Demolish 1 house (60 Sea Lane); partially demolish 1 house (45 The Ridings); construct 3 detached houses; alterations and extensions (45 The Ridings)
45 The Ridings and 60-62 Sea Lane East Preston

Thank you for your internet representation made on 9th May 2013 which has been recorded as '**an objection**' with the comments as follows:

*Objection to Planning Application EP/111/12
House Number 45 & 47 The Ridings*

STREET SCENE (THE RIDINGS)
SCALE 1:100

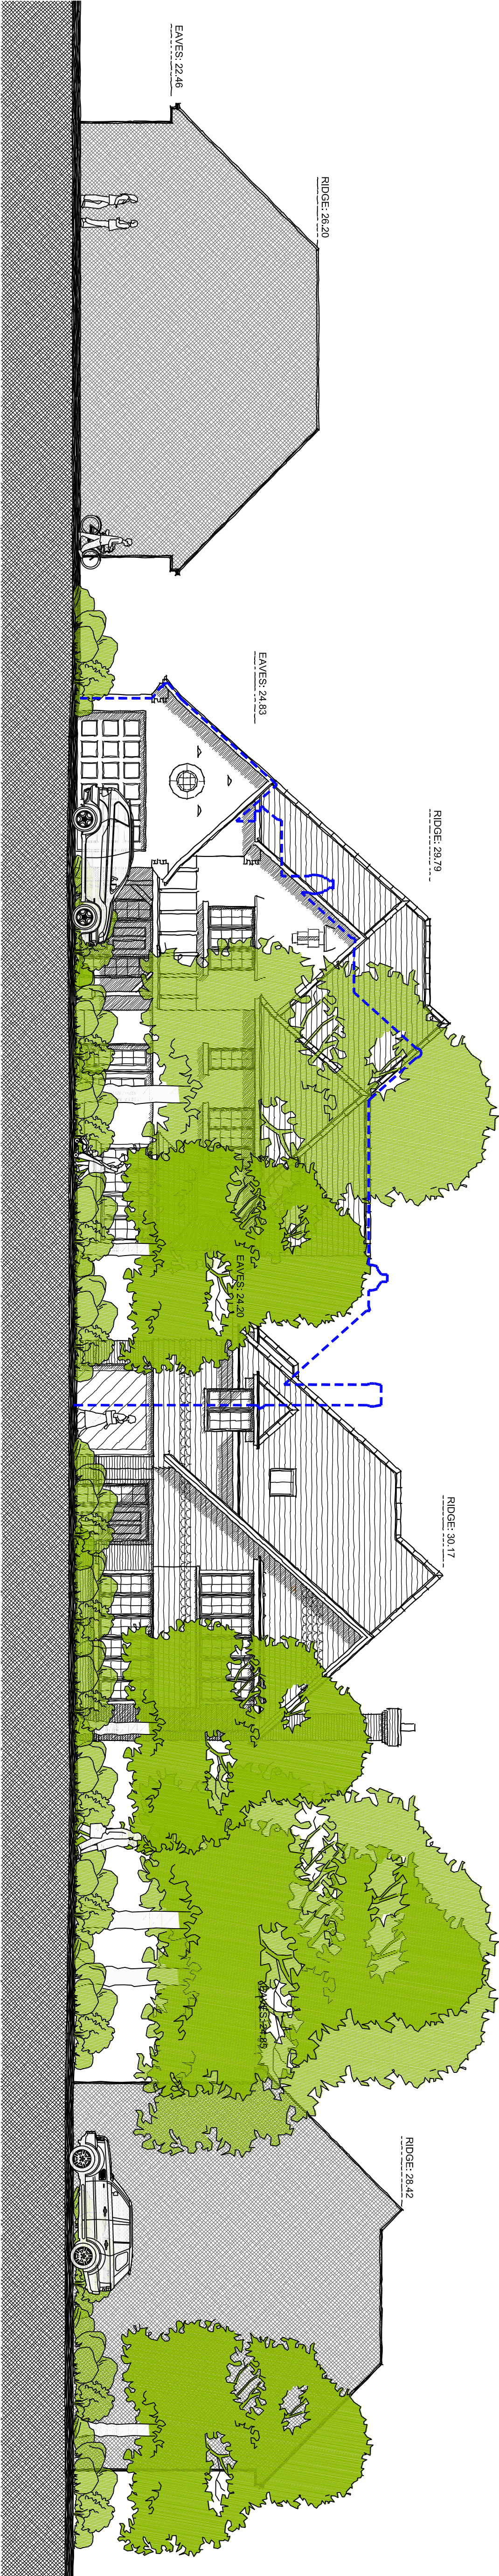
Clearly Number 47 will be substantially higher than the surrounding properties as identified on the elevation drawing and this height difference being 1.75m compared to the adjacent house number 49. The height of number 47 will be substantially higher than our house.

My objection to this height issue is based upon the fact that the new property will be able to look directly into our lounge and sitting room areas from the top floor and that it will be unsympathetic to the context of the existing street landscape.

PROPOSED FLOOR PLANS &
ELEVATIONS
NO. 45 THE RIDINGS

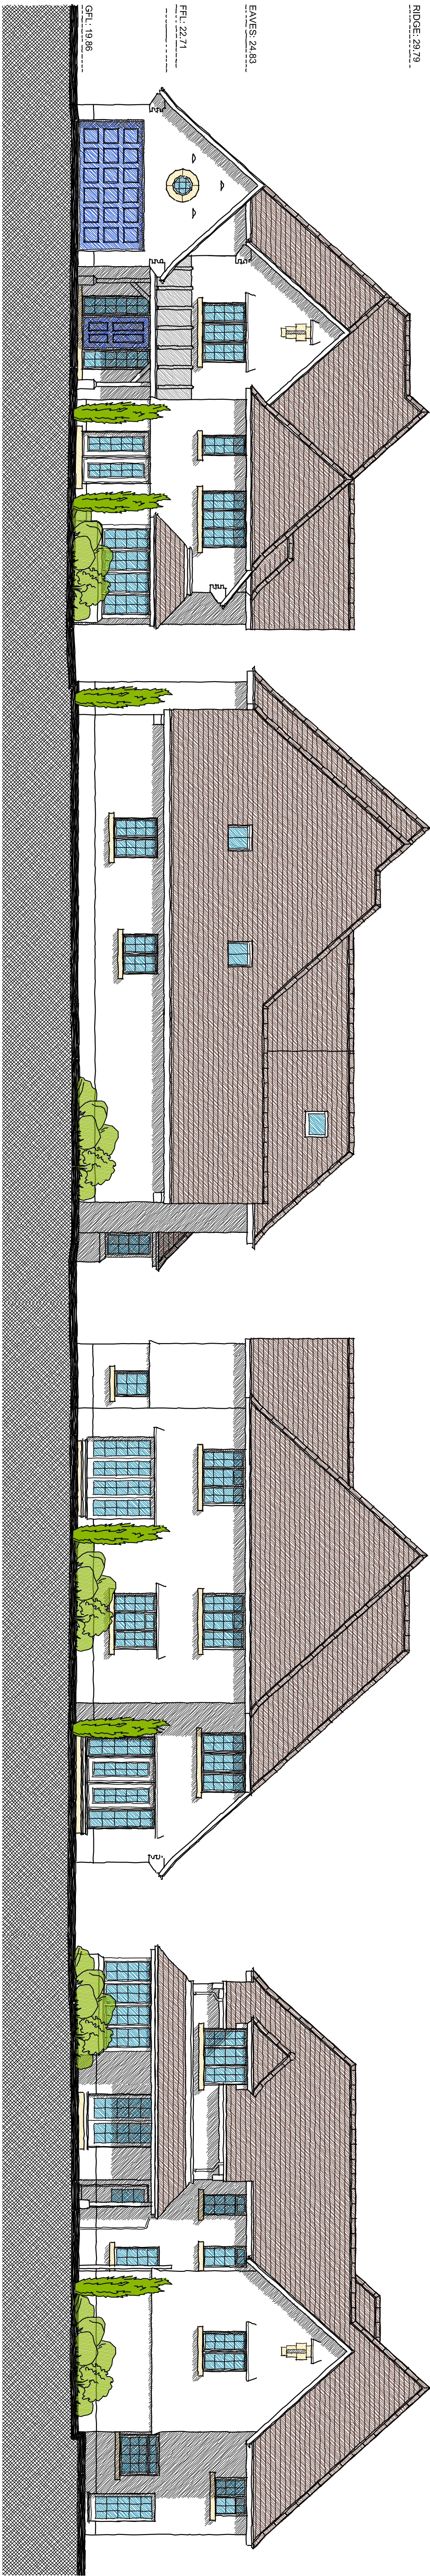
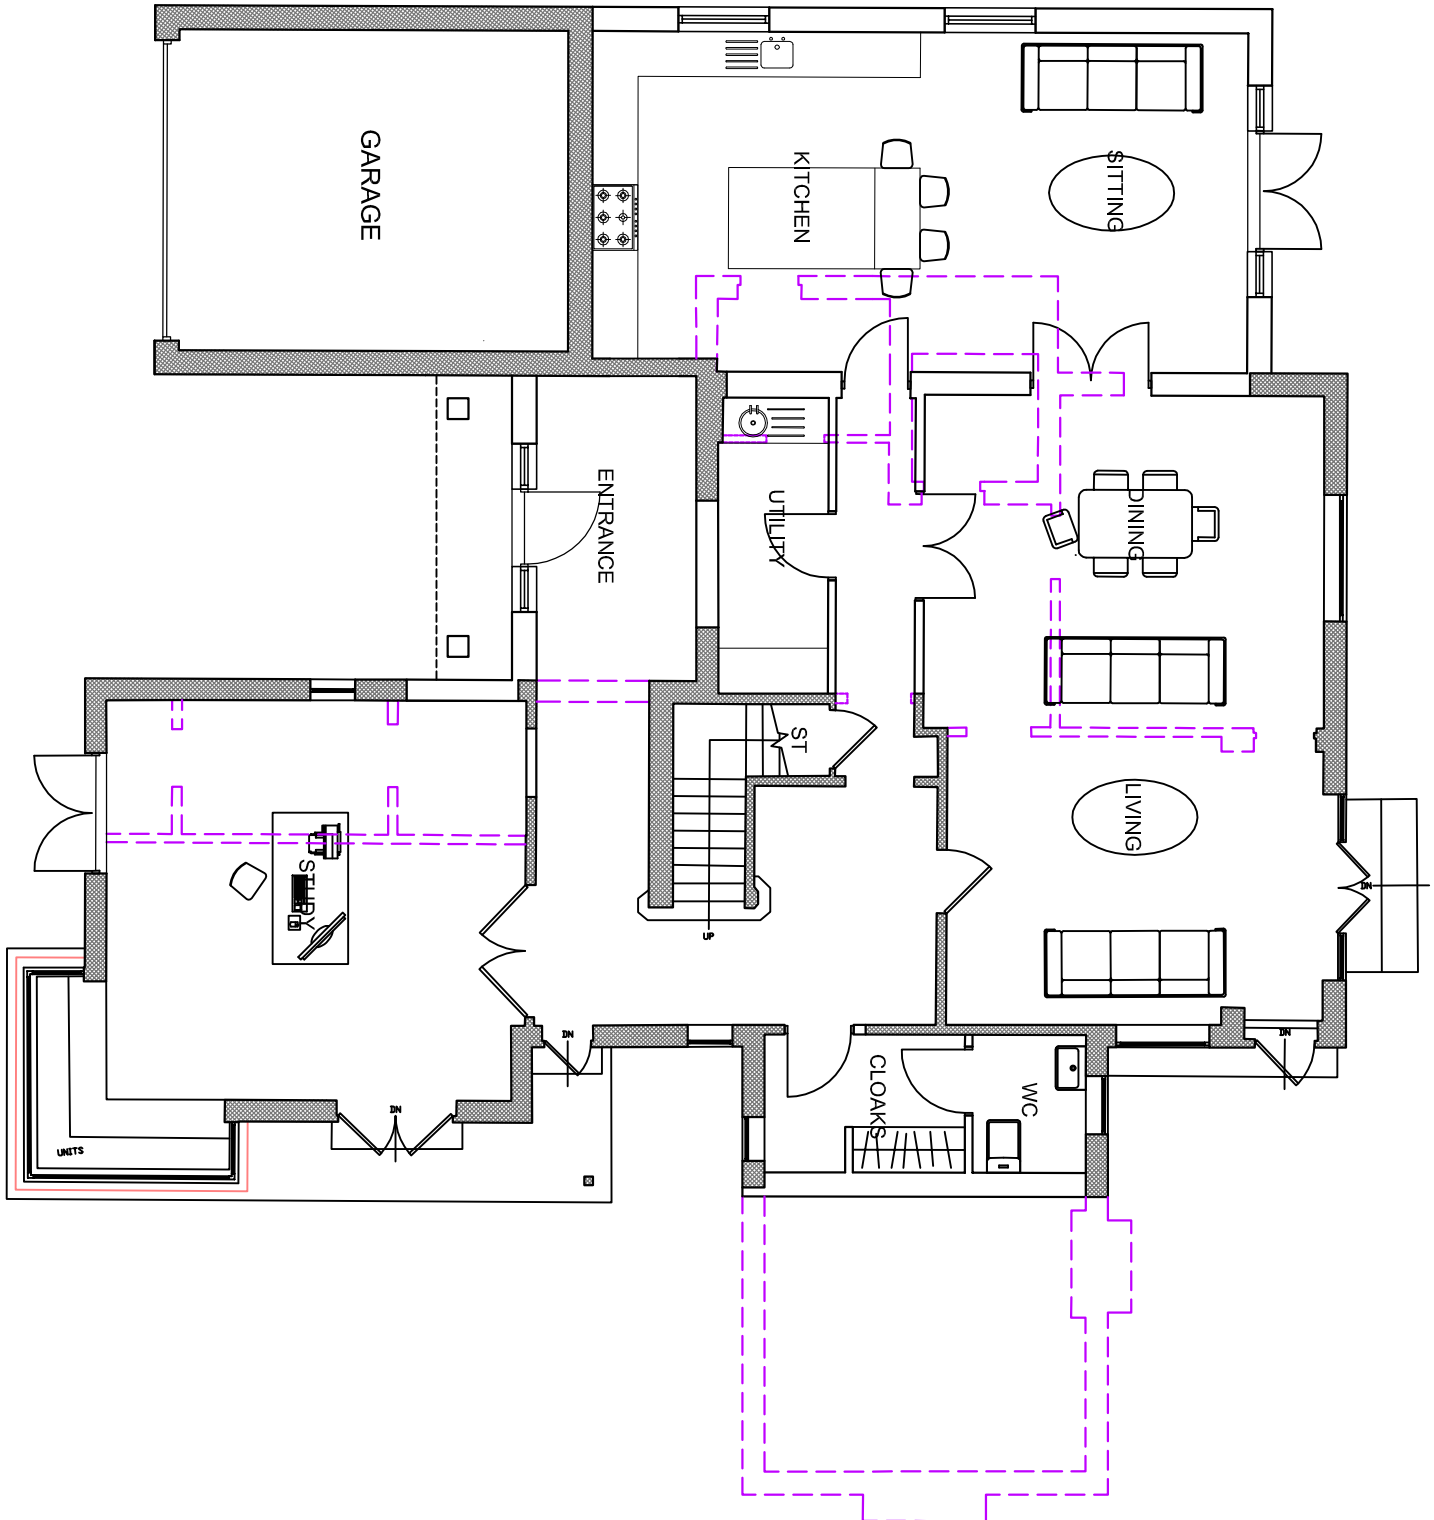
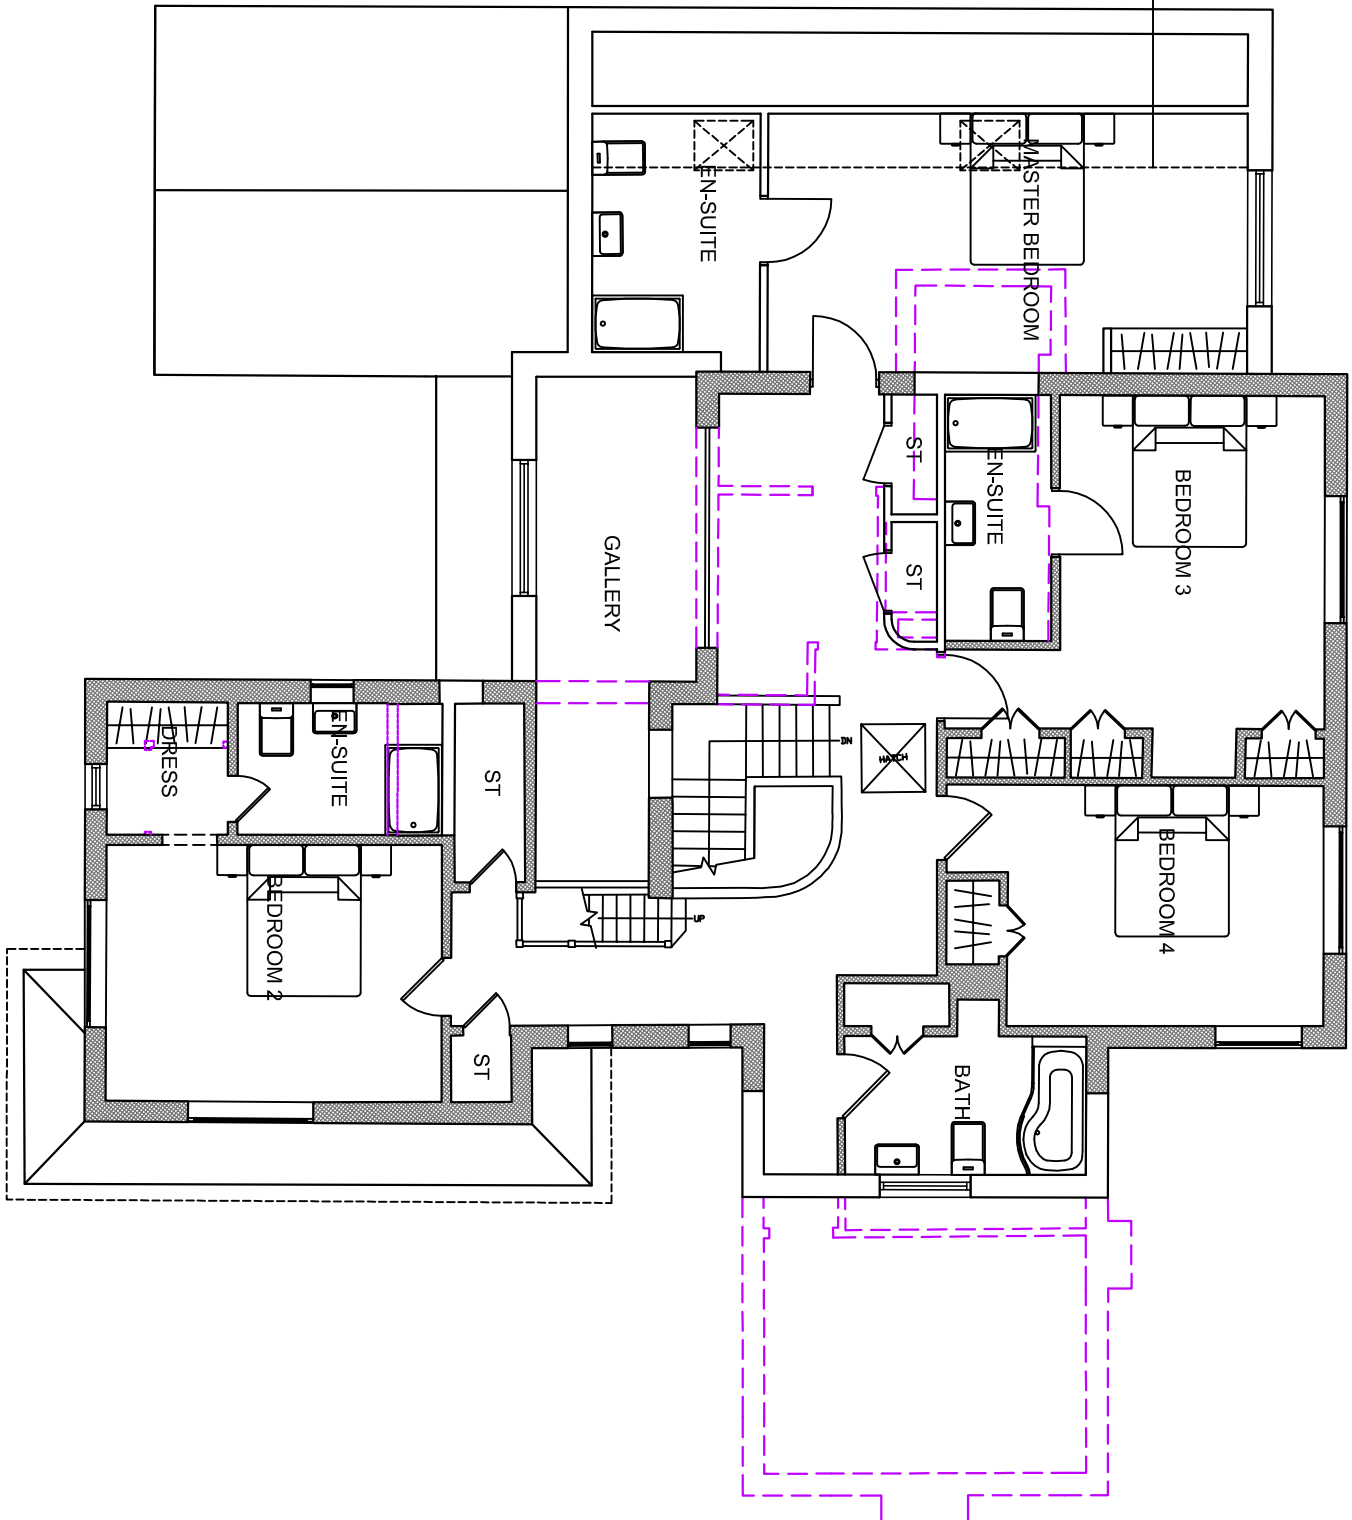
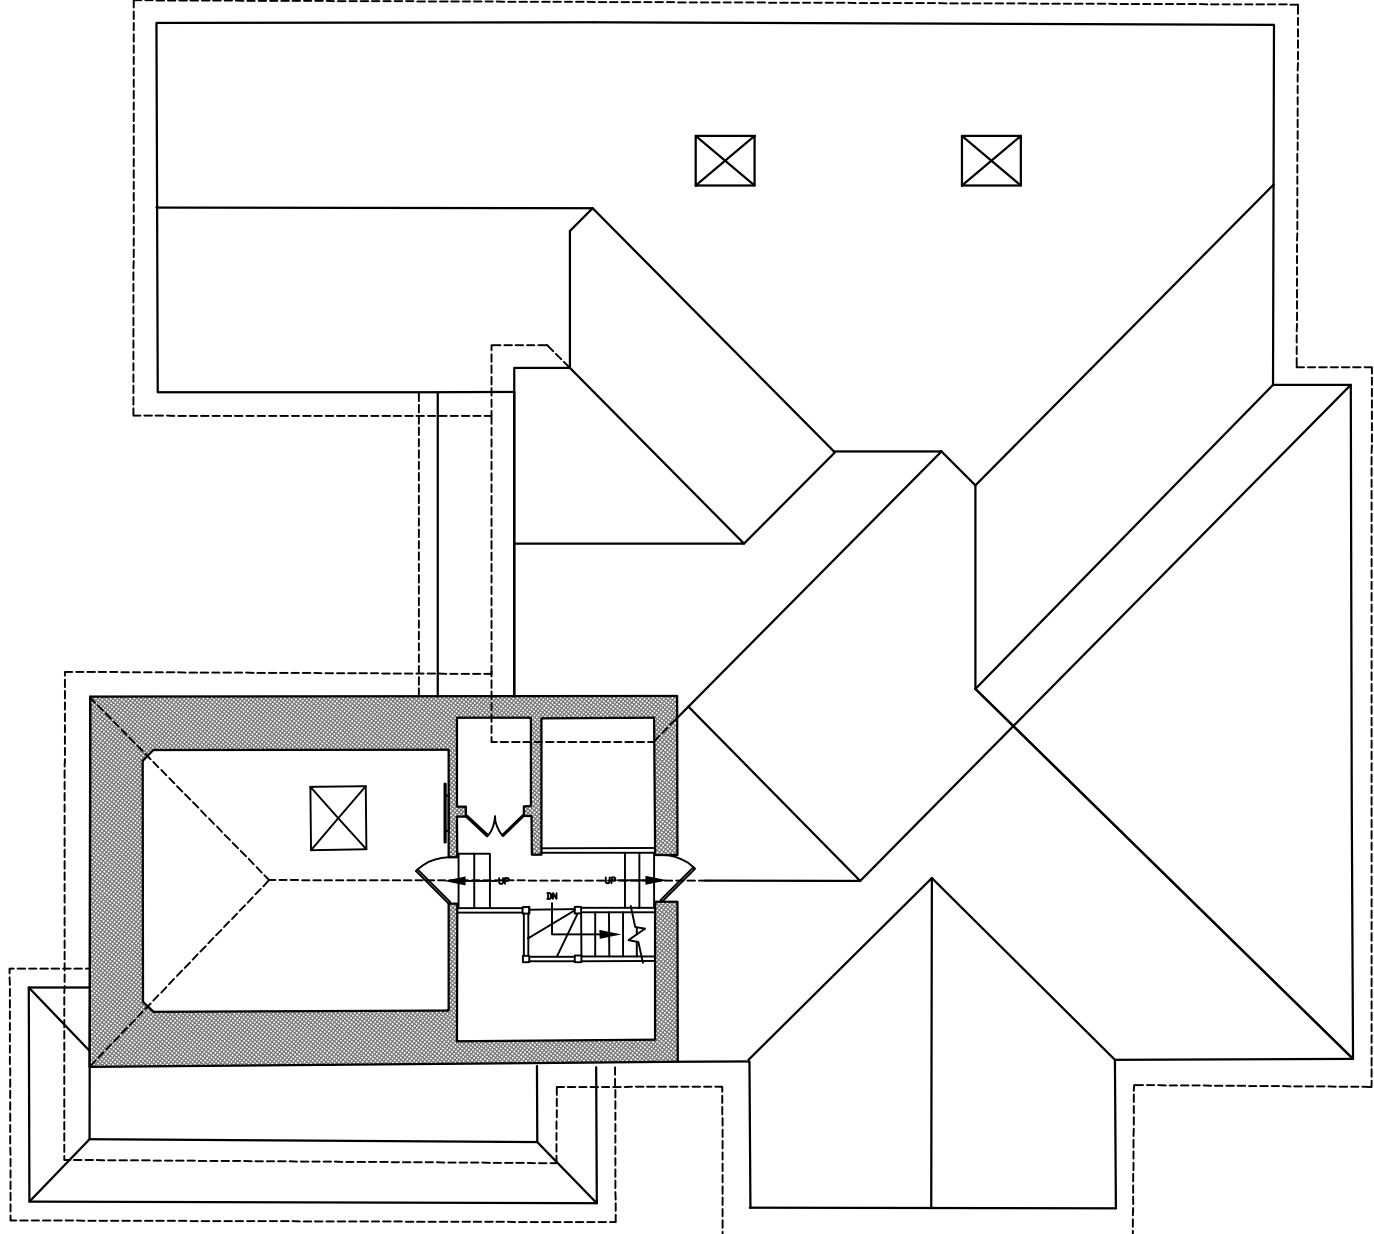
I would draw your attention to, it appears that number 45, the existing house to be refurbished, is also being increased in height and this would go against the design statement of the East Preston Village Parish council.
